From: Sian Eggington [REDACTED]
Sent: 12 November 2018 09:02
To: Sian Eggington
Subject: FW: Further Information Required on Your Ref: PP-07376702 Our Ref: WA/98/18/HH
Attachments: GABLE HOUSEPlanAppAmmendments November_07.pdf; GABLE HOUSEPlanAppAmmendments November_08.pdf
Categories: Orange Category

From: Andrew Ratcliffe [REDACTED]
Sent: 11 November 2018 15:01
To: Planning.Responses
Subject: Re: Further Information Required on Your Ref: PP-07376702 Our Ref: WA/98/18/HH

Site plan, 1:100 at A2
(All dimensions in mm unless otherwise stated)

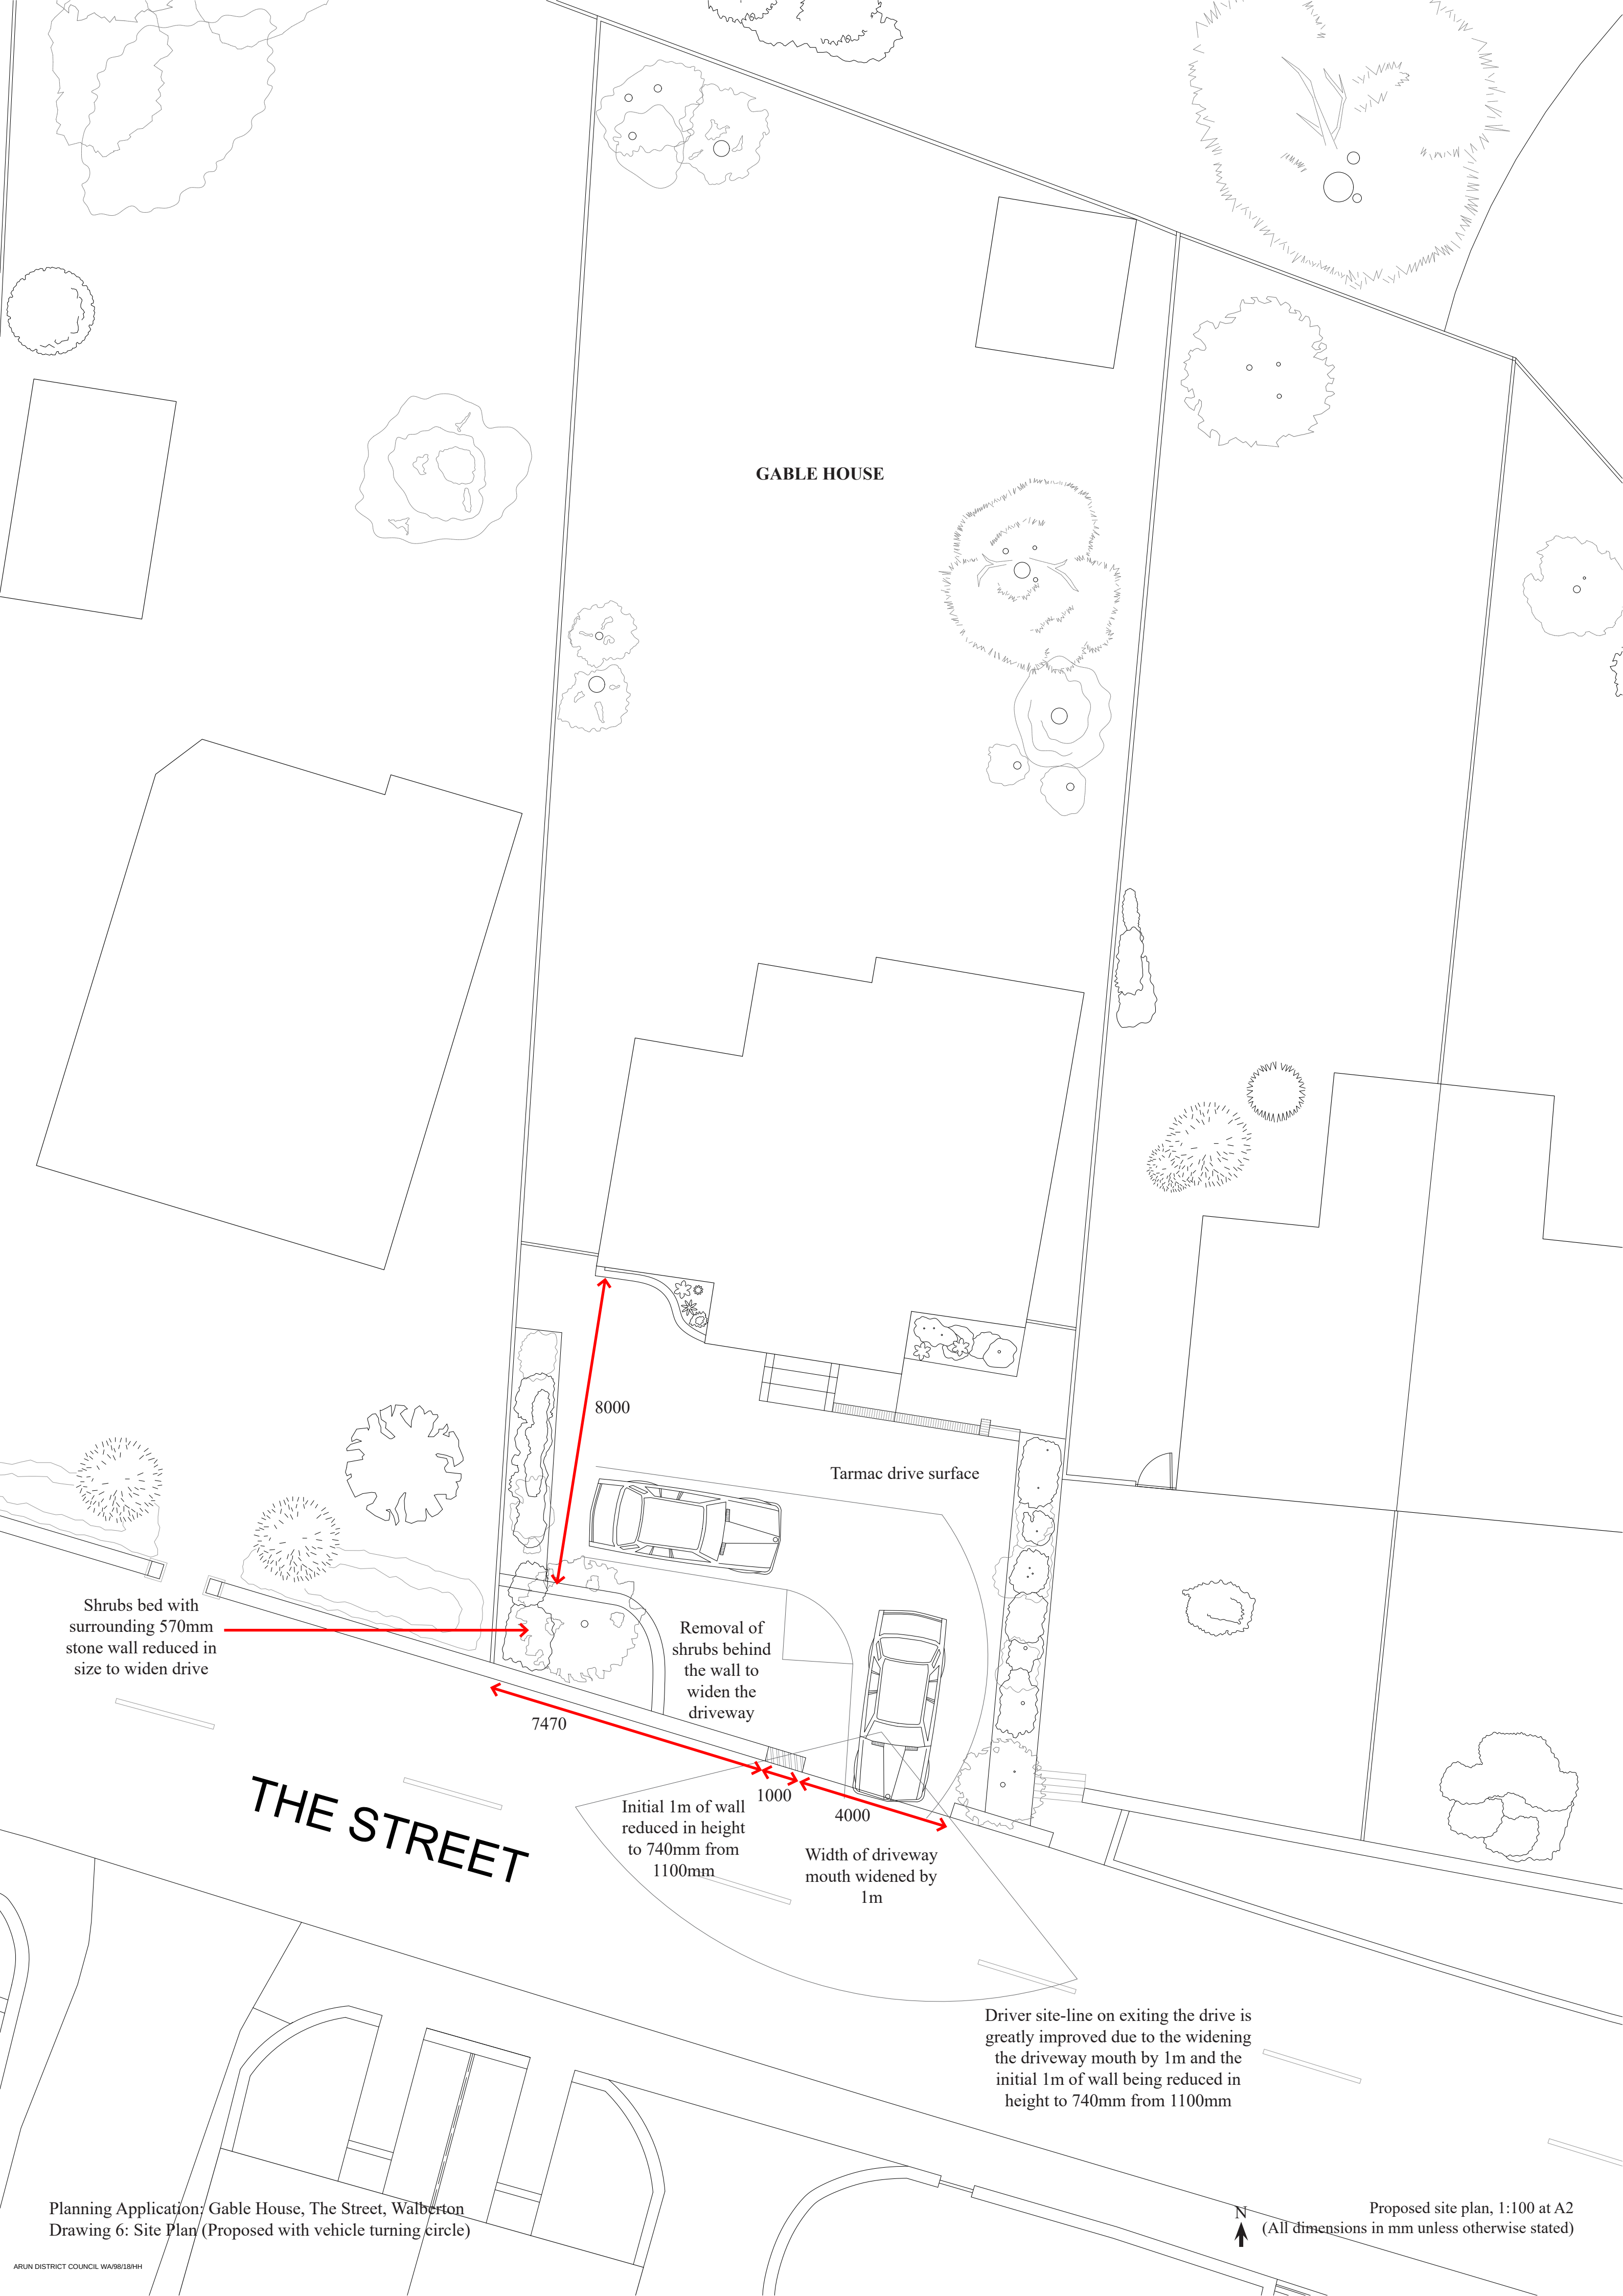
Dimension Incorrect: The dimension '14510' on the 1:50 plan does not measure to scale. Apologies for this mistake. Please find attached corrected drawings.
